**KIRKLEES METROPOLITAN COUNCIL
INVESTMENT & REGENERATION SERVICE**

**DELEGATED DECISION TO DETERMINE APPLICATIONS FOR
CONSENT, AGREEMENT OR APPROVAL REQUIRED BY CONDITION**

Reference No:	2022/44/92236/E
Site Address:	Field House, 15 Wellington Street, Dewsbury, WF13 1BQ
Description:	Discharge of conditions 3 (detailed drawings), 4 (additional storey), 5 (materials), 6 (residential waste), 7 (A3 use waste), 9 (swift nesting), 14 (ventilation), 15 (noise assessment) and 19 (air quality) of previous permission 2019/92962 for erection of additional storey and conversion of building to provide 23 self-contained apartments and A3 use in basement and part of ground floor (Listed Building within a Conservation Area)
Recommending Officer:	Victor Grayson

DECISION – Discharge of Conditions- Split Decision

01 Site Refuse Strategy Plan
Scale: 1:100

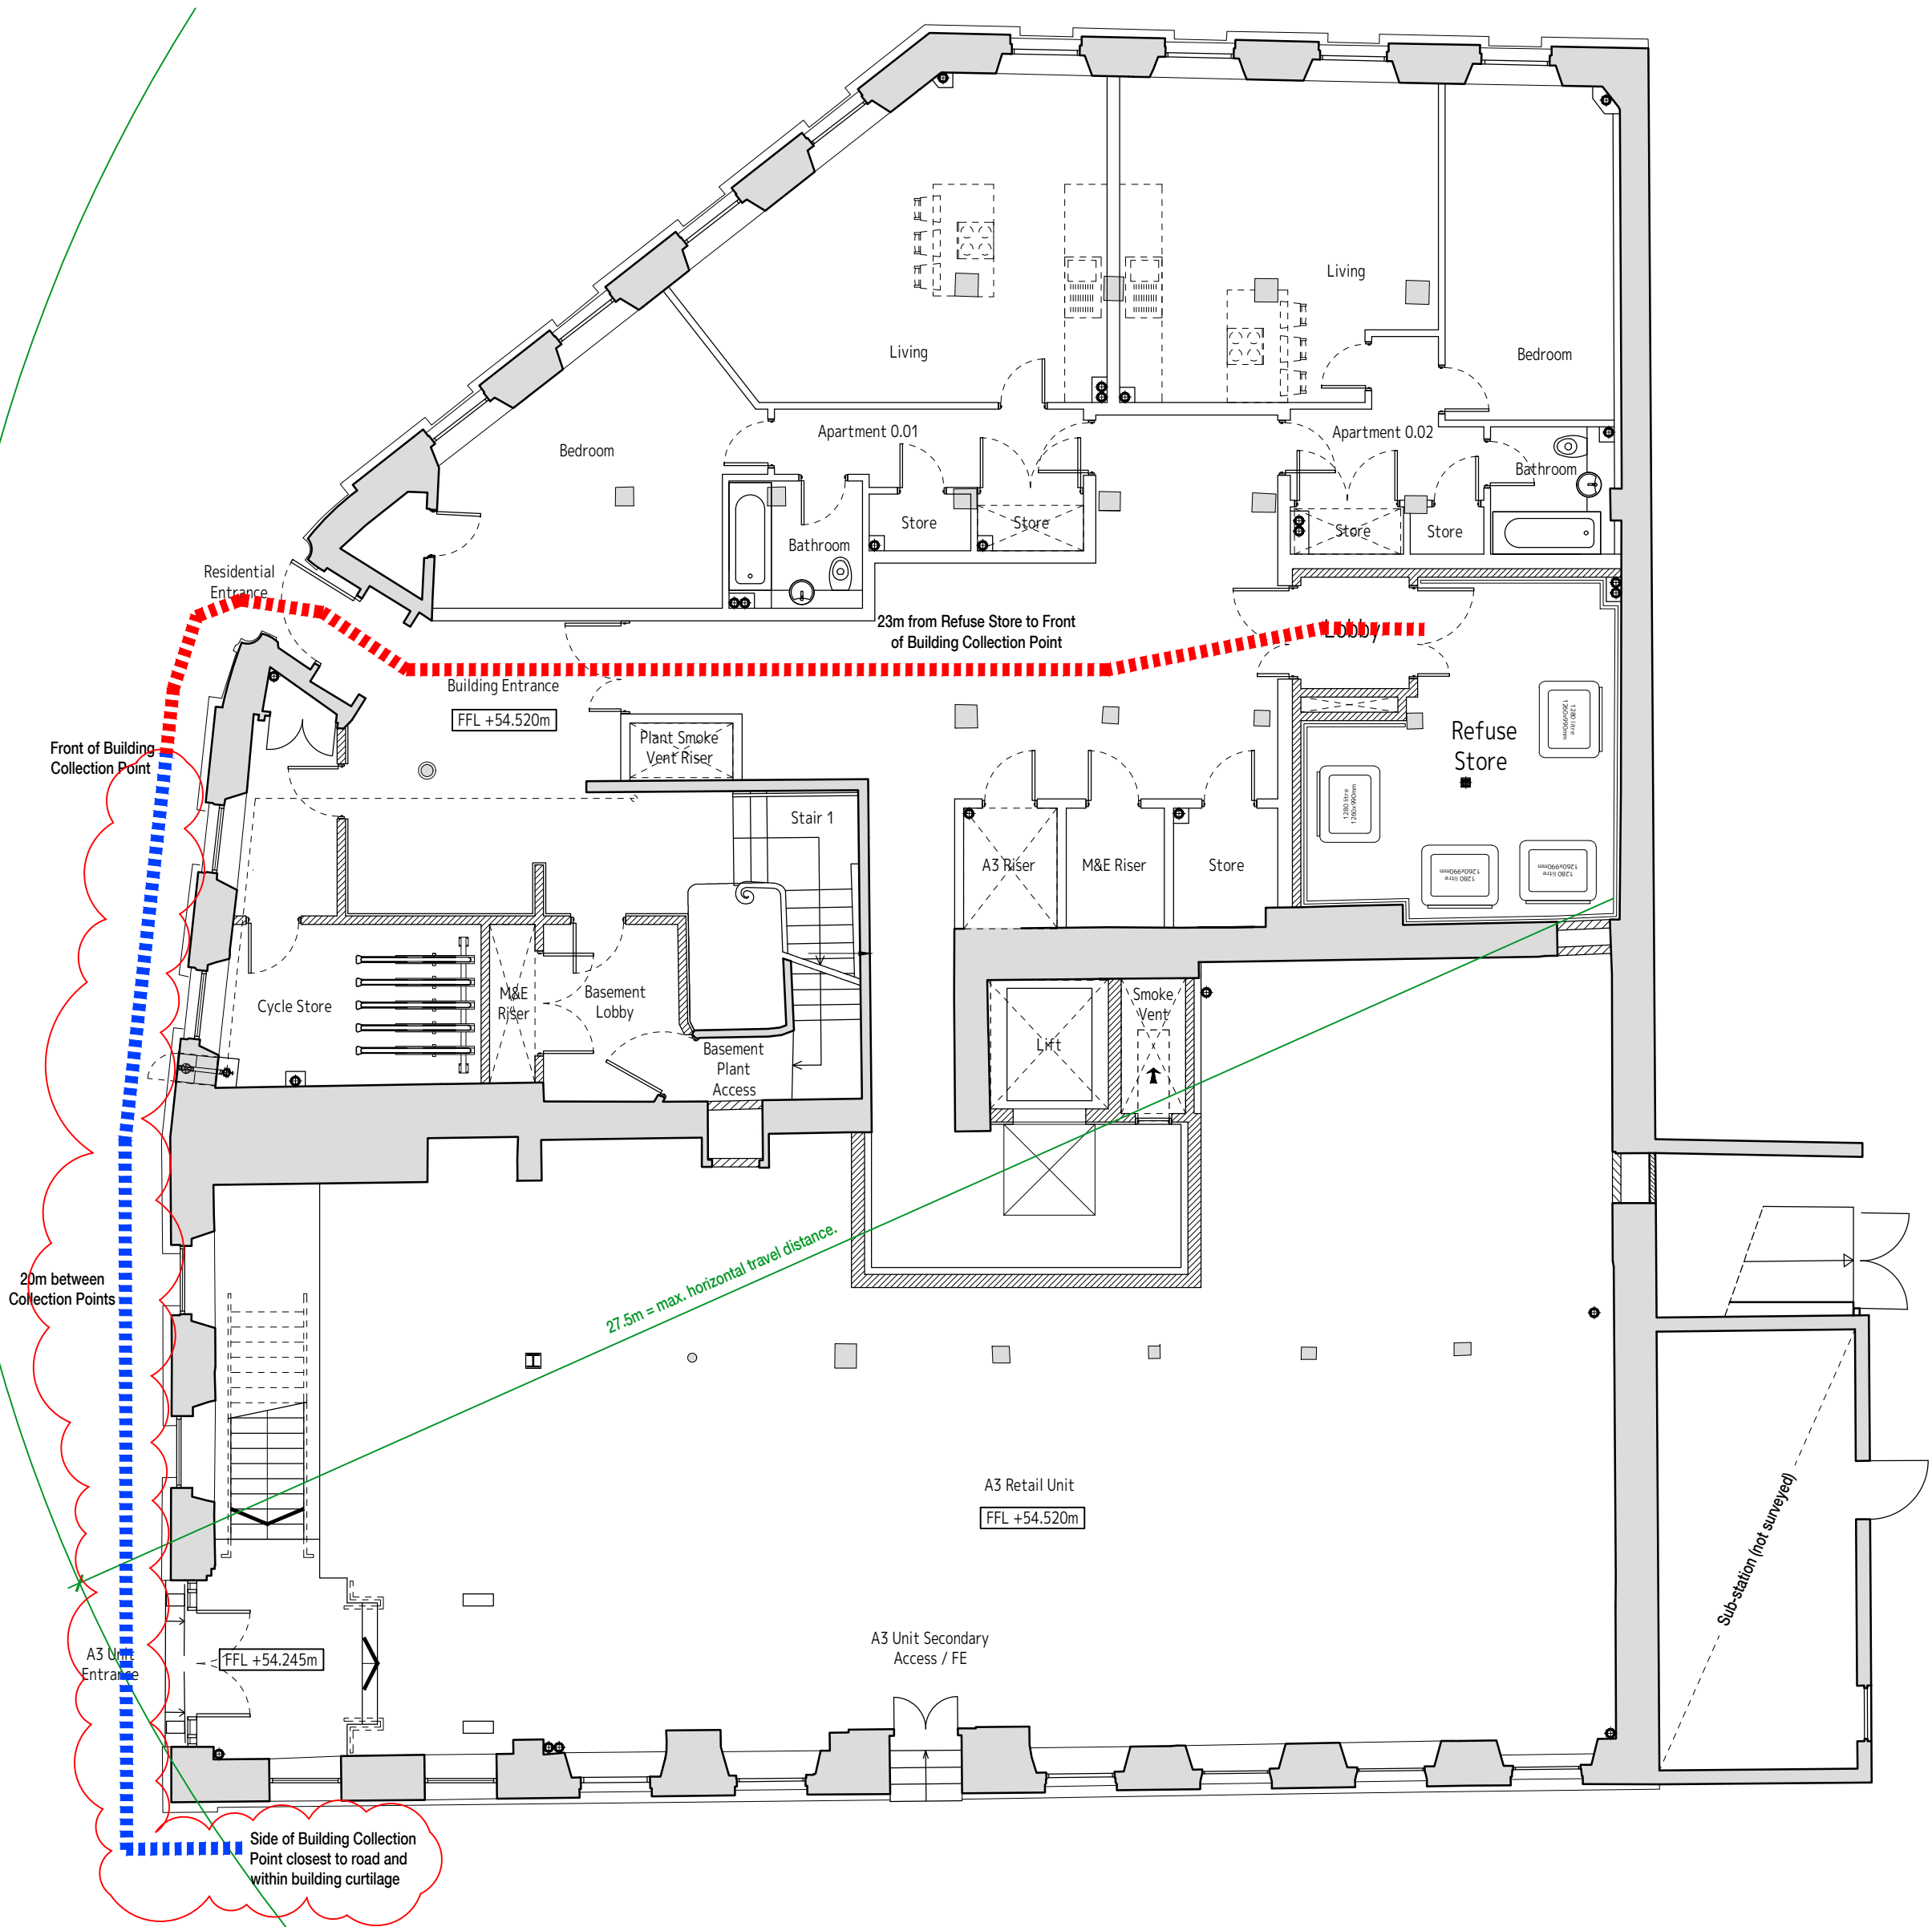
Despite some changes the proposals do not really address the waste issues identified by Carol Oakden in her response to the 2019 planning application e.g. location of store with access through lobby to main entrance and then no close location for access of an RCV.

The currently proposals include waste storage in the retail unit using a rear access door and ramp that with a change to the internal layout (depending on floor levels) may be a more acceptable solution for the whole building.

This is a difficult site to service and waste issue could be a long term problem if not resolved.

The new identified collection points to the side of the building will hopefully offer a more discreet location and ease collection as they are nearer to the road/kerbside.

We have marked the routes to the side of the building as additional to the original locations as they are now in excess of 25m but it is agreed they are a better location for collection.

It is also confirmed that the bins will be wheeled out to the agreed collection points and back again by the building management and the tenant for residential and A3 unit waste respectively on the day of collection.

I can confirm that the commitment for the management company / caretaker to be responsible for moving / putting out / returning bins from the internal bin store to a Bin Collection Point on the corner of Wellington Street at the location shown on the plans is acceptable and therefore the conditions can be discharged.

Given the above advice, it is recommended that the information submitted pursuant to condition 6 be approved.
